GRADING AND EROSION CONTROL PLAN

WYOMING ESTATES SUBDIVISION EL PASO COUNTY, CO

DRAINAGE, GRADING
AND EROSION
CONTROL COVER

DRAINAGE, GRADING
 AND EROSION
 CONTROL PLAN

DRAINAGE, GRADING
AND EROSION
CONTROL PLAN

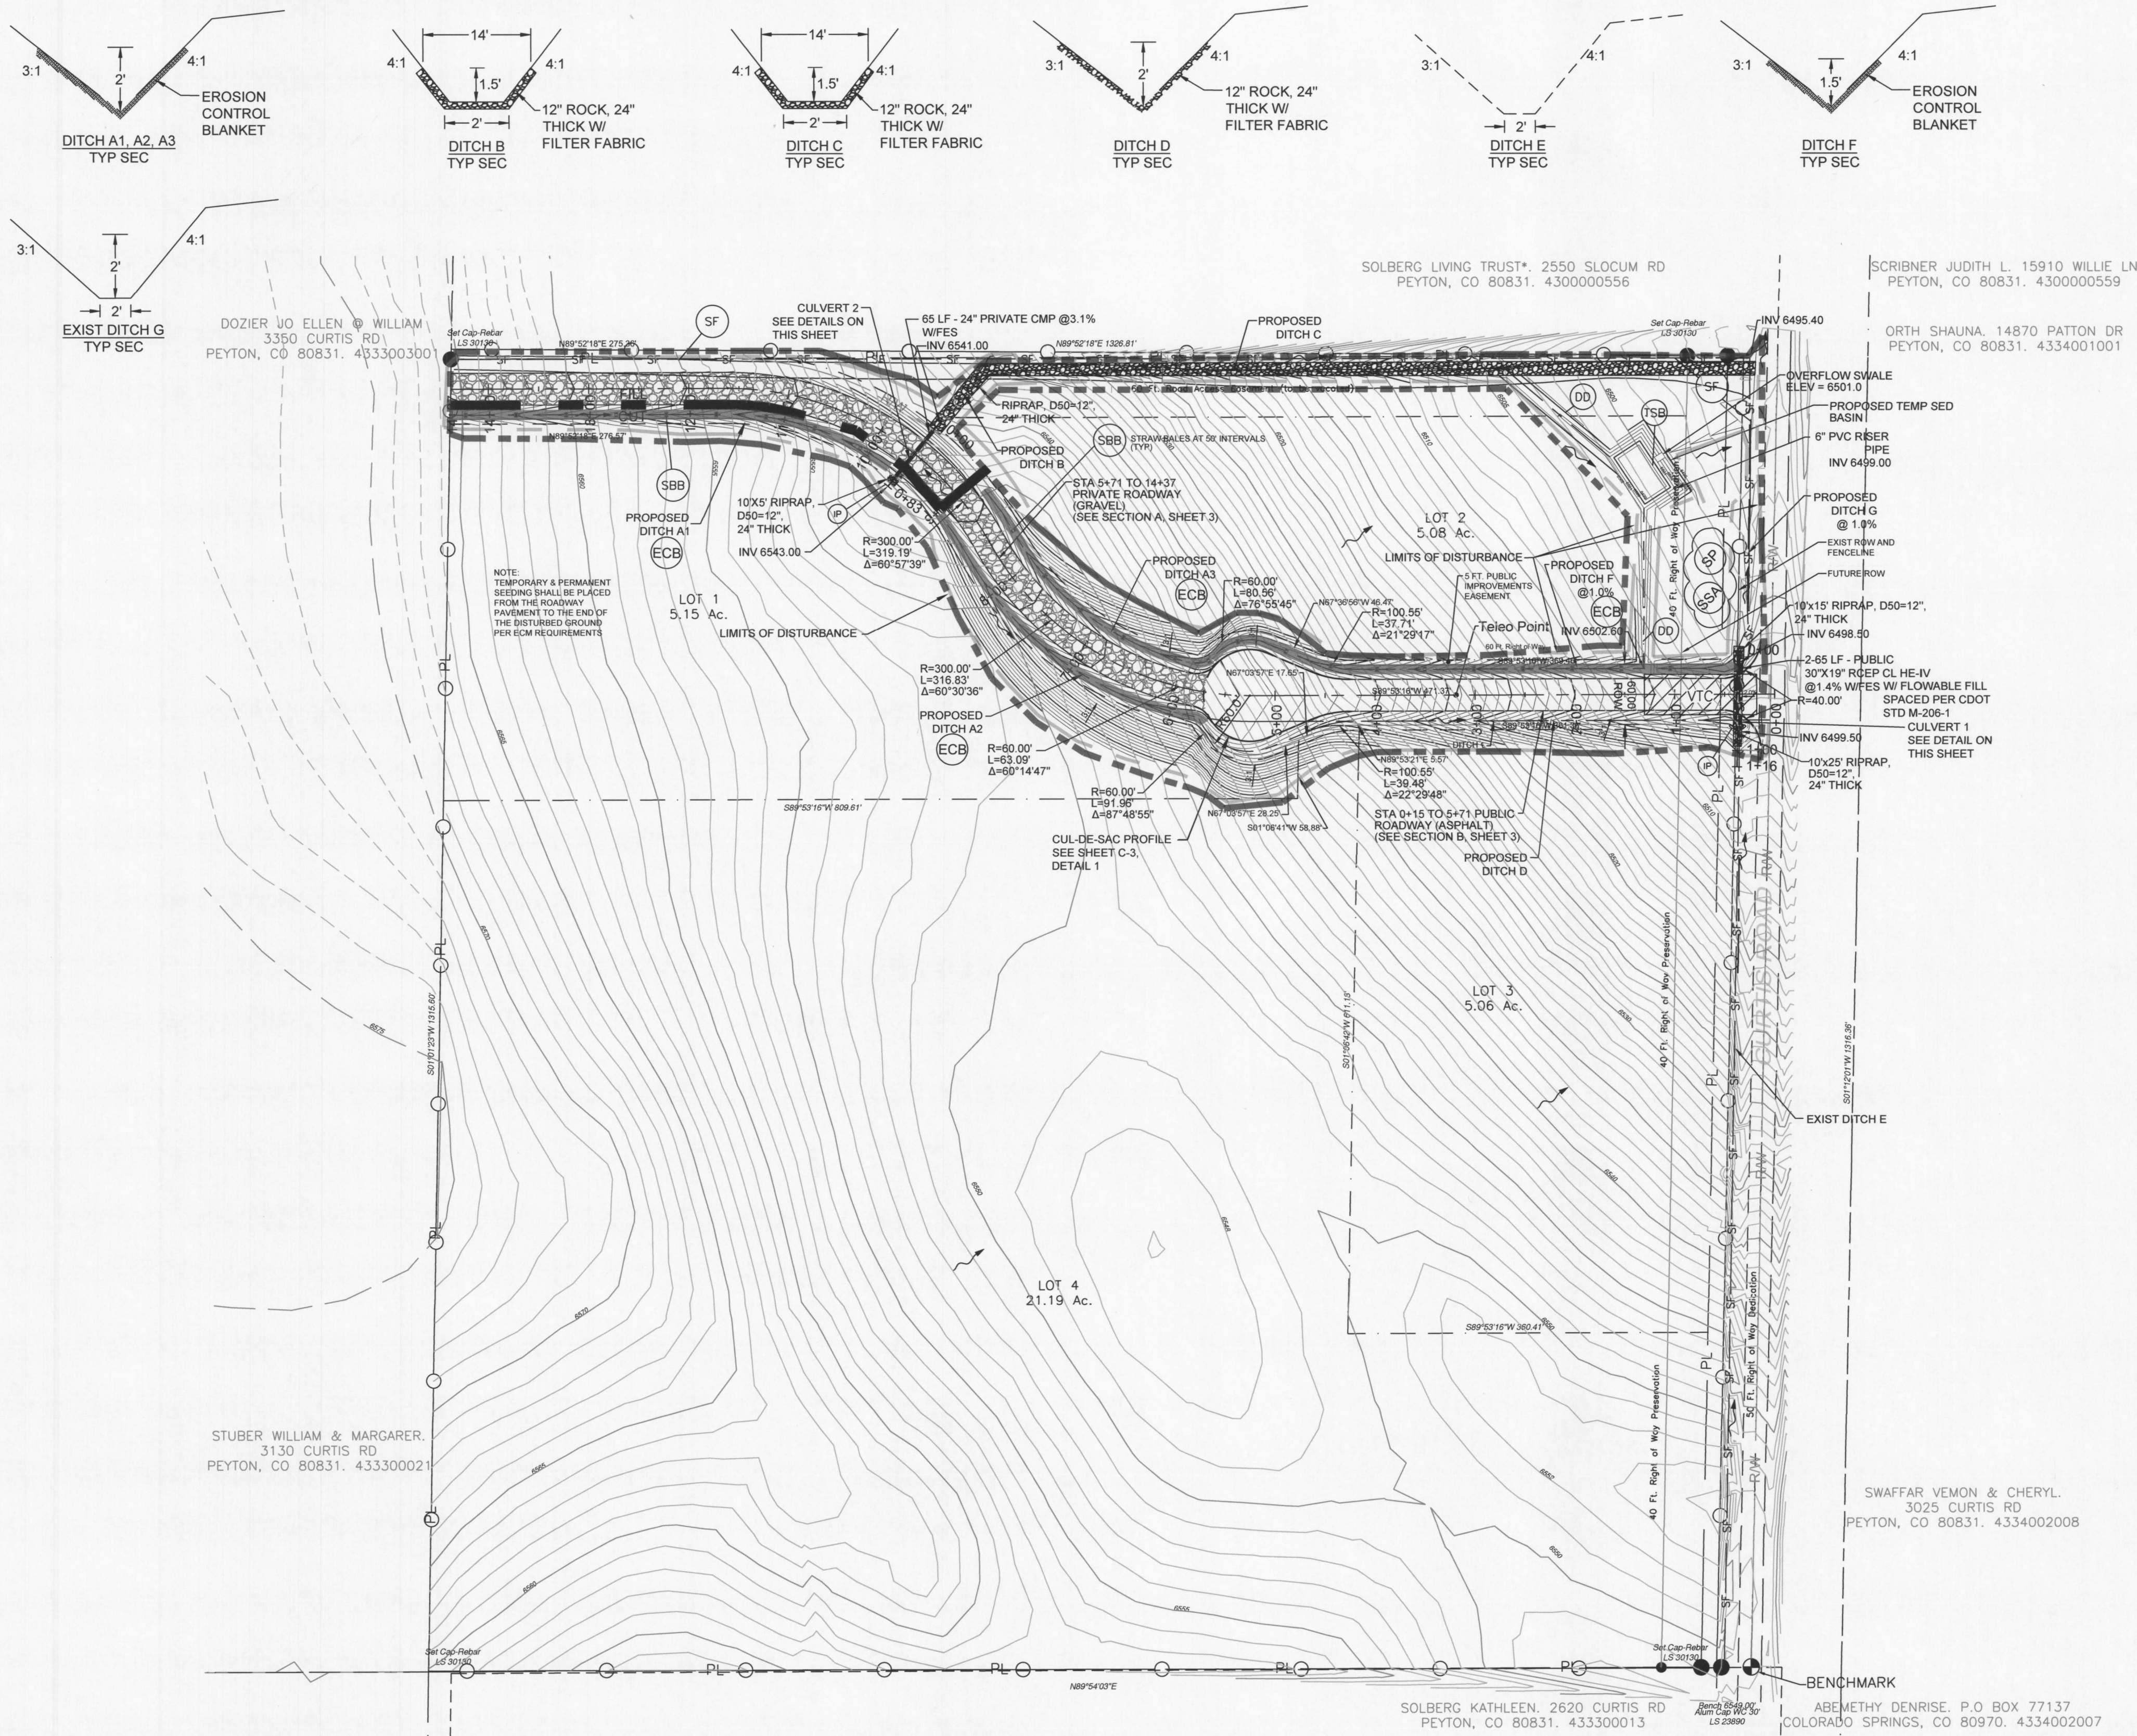
Provide contour labels for the sediment basin. Additionally provide the sediment basin required and provided volume and riser pipe construction information such as the pipe diameter per the review 1 comment.

Please show the contours for the drainage ditch
